Consultation Response from KC, Conservation and Design
2020/90479 Parkwood Methodist Church, Parkwood Road, Longwood, Huddersfield, HD3 4TT
Alterations to convert former church to 12 residential units, formation of parking areas and widen vehicular access (Listed Building within a Conservation Area)
Date Responded: 30/10/20
Responding Officer: Craig McHugh
Responding Ref: HUD 32/363

Revised following receipt of amended plans

- Revised Proposed Site Layout 17-D23-07E
- Revised Plans and Elevations 17-D23-06

Lower Ground Floor

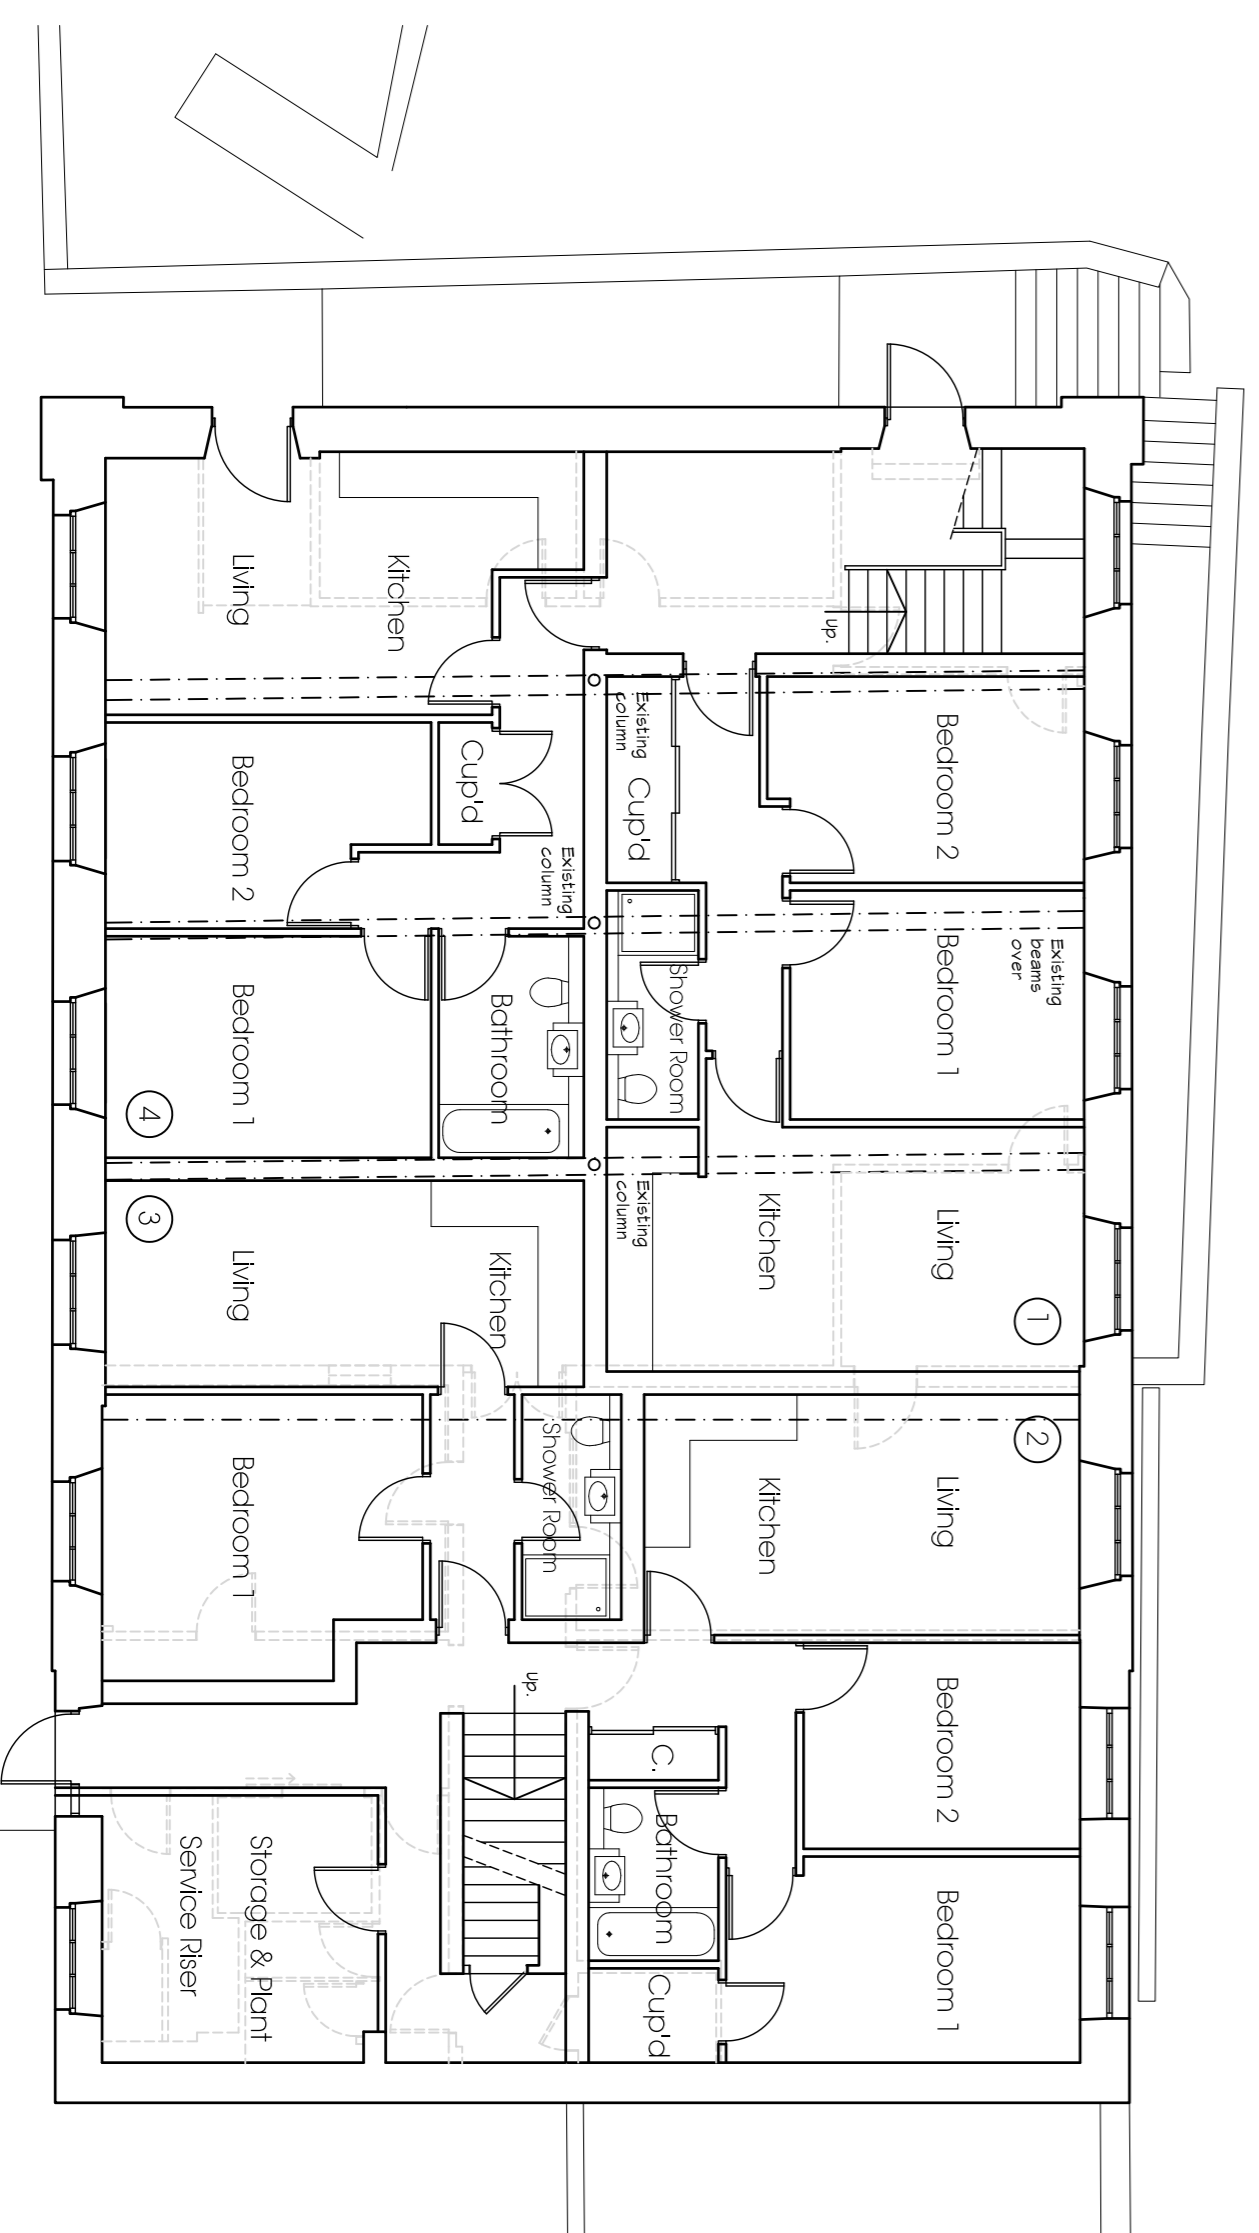
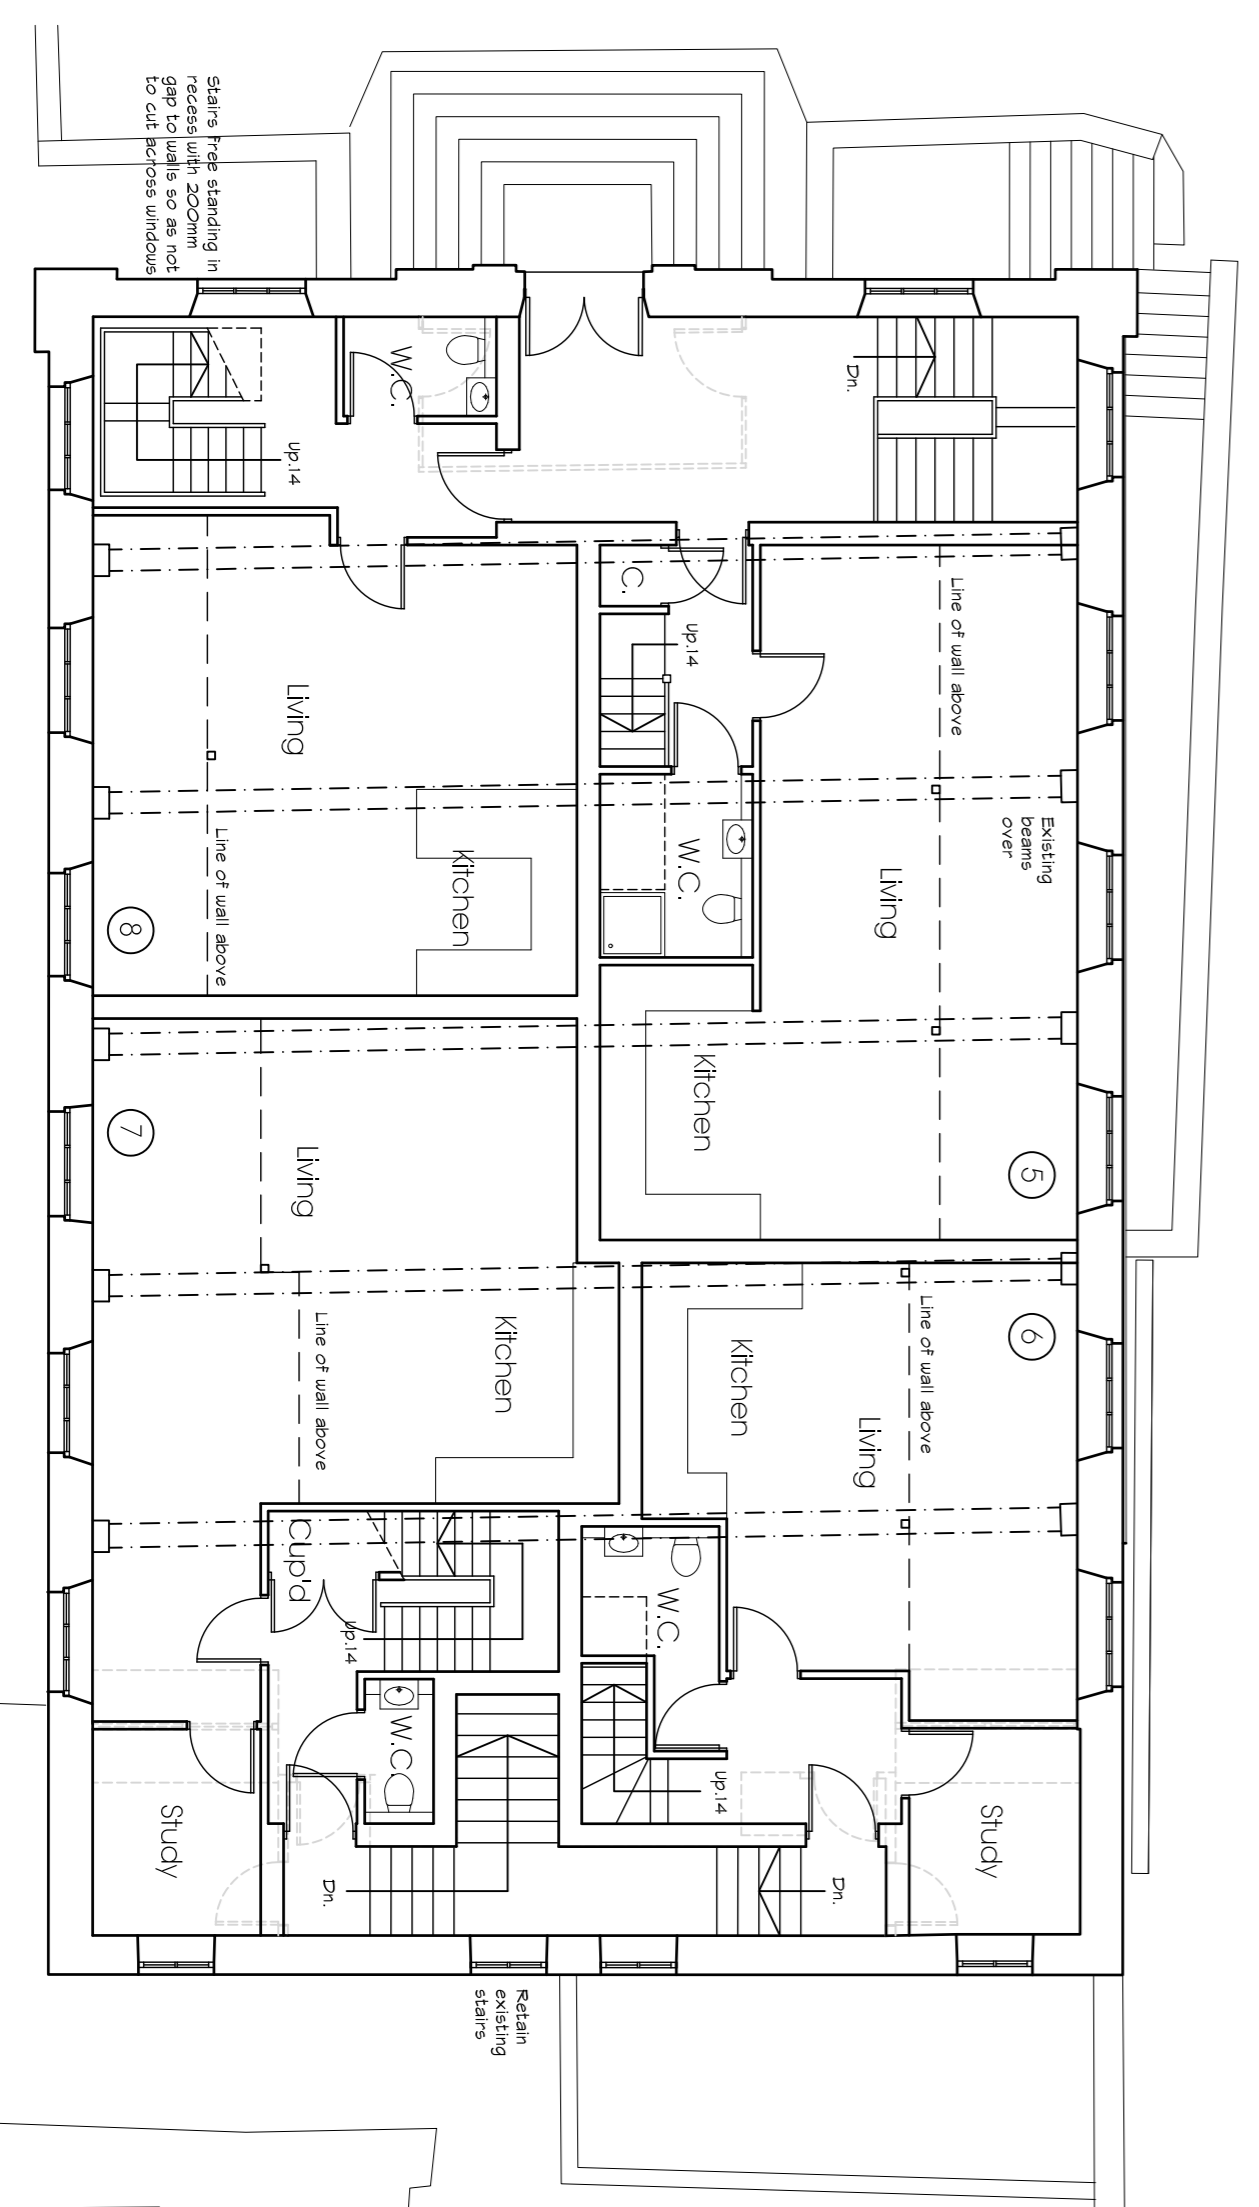
The proposed development would lead to the complete loss of the plan form of the building, with the main body of the church subdivided horizontally and vertically, the loss of all interior joinery and the loss or hiding of its decorative ceiling beams. All windows and doors would be replaced including the memorial windows.

With regards to paragraph 193 of the NPPF, the level of harm would be very high and little short of substantial harm.

A very high level of harm would result from the proposed development. This requires very robust justification including a viability appraisal for this and other less harmful alternative uses or residential conversion schemes, which has still not been provided. The tests of paragraphs 194 and 196 have not been met.

Conservation and Design object to the proposed development on heritage grounds, particularly with regards to paragraphs 193, 194 and 196 of the NPPF. It would cause a very high level of harm to Parkwood Methodist Church and some harm to Longwood Edge Conservation Area, that harm would still be less than substantial harm.

If a residential use is the most appropriate use, then a less intensive conversion should be considered which seeks to:

- retain the memorial windows in situ
- retain interior features wherever possible through a creative approach to subdivision and interior design
- retain some sense of the layout of the building and the volume of the main body of the church
- retain more of the memorial gardens to better preserve the landscape setting of the church and the character and appearance of the conservation area
